Recommendation Report for Planning Permission**REF NO:** FP/179/11/**LOCATION:** 30 Limmer Lane
Bognor Regis**PROPOSAL:** Demolition of existing dwelling & outbuildings & erection of 6 no. apartments with associated parking & landscaping (re-submission following FP/182/10/)**SITE AND SURROUNDINGS**

#	LO	01/03/2012	1st Issue
Rev	By	Date	Note
Client John Owen			
Job 30 Limmer Lane Felpham, Bognor Regis, West Sussex.			
Drawing Proposed Apartments Highway works and Visibility			
Date	January 2012	Scale	1:100@A1 1:200@A3
Drawn By	L.O.	Dwg. No.	030510/SL-41

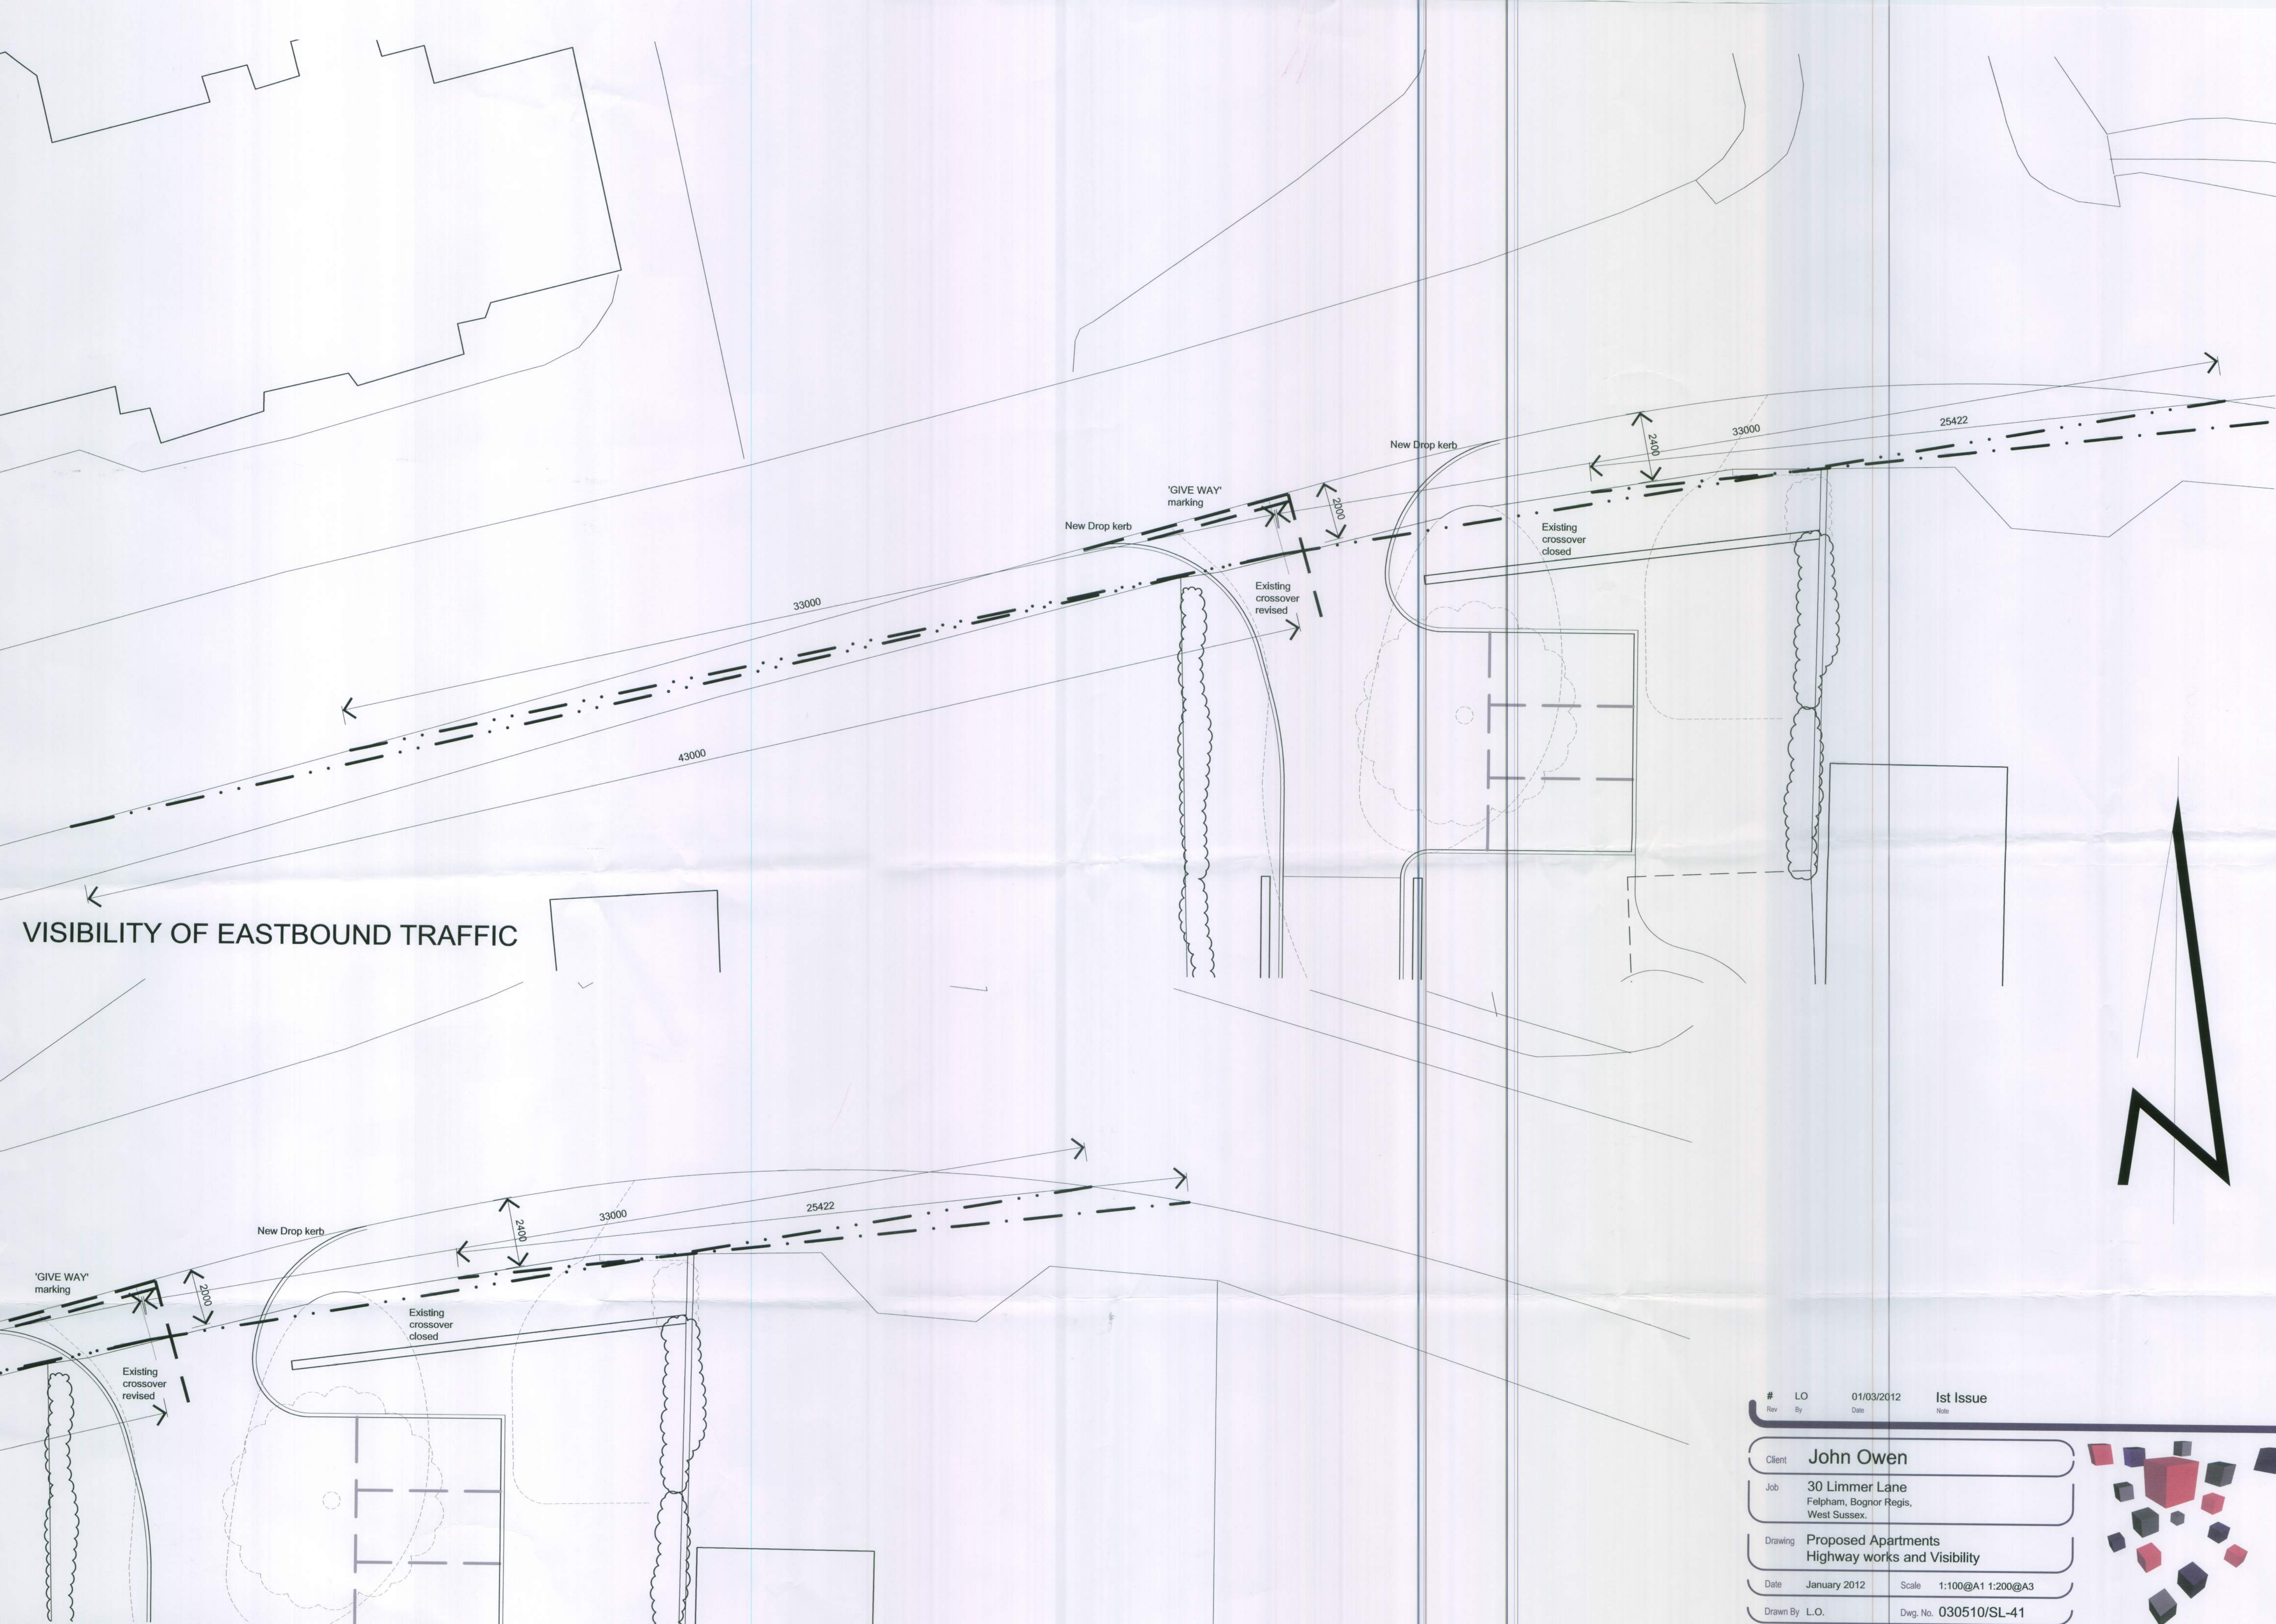
Recommend refusal. From the plans submitted it appears that appropriate visibility cannot be achieved without affecting third party land to the east of the proposed access position.

Notwithstanding the fact that this proposal does involve closure of the existing access, where visibility to the east is even less than that proposed, and the formation of a new access the

development of 6 apartments will result in an increase in vehicular movements over what currently exists. As a result the new access is unacceptable and does not meet appropriate standards.

The highway advice confirms that the proposal to close one existing crossover and modify the other does not provide the required visibility and therefore does not constitute a safe access arrangement.

- 1 The access is unsatisfactory to serve the proposed development of 6 apartments by reason of inadequate visibility in conflict with policy GEN7 of the Arun District Local Plan.
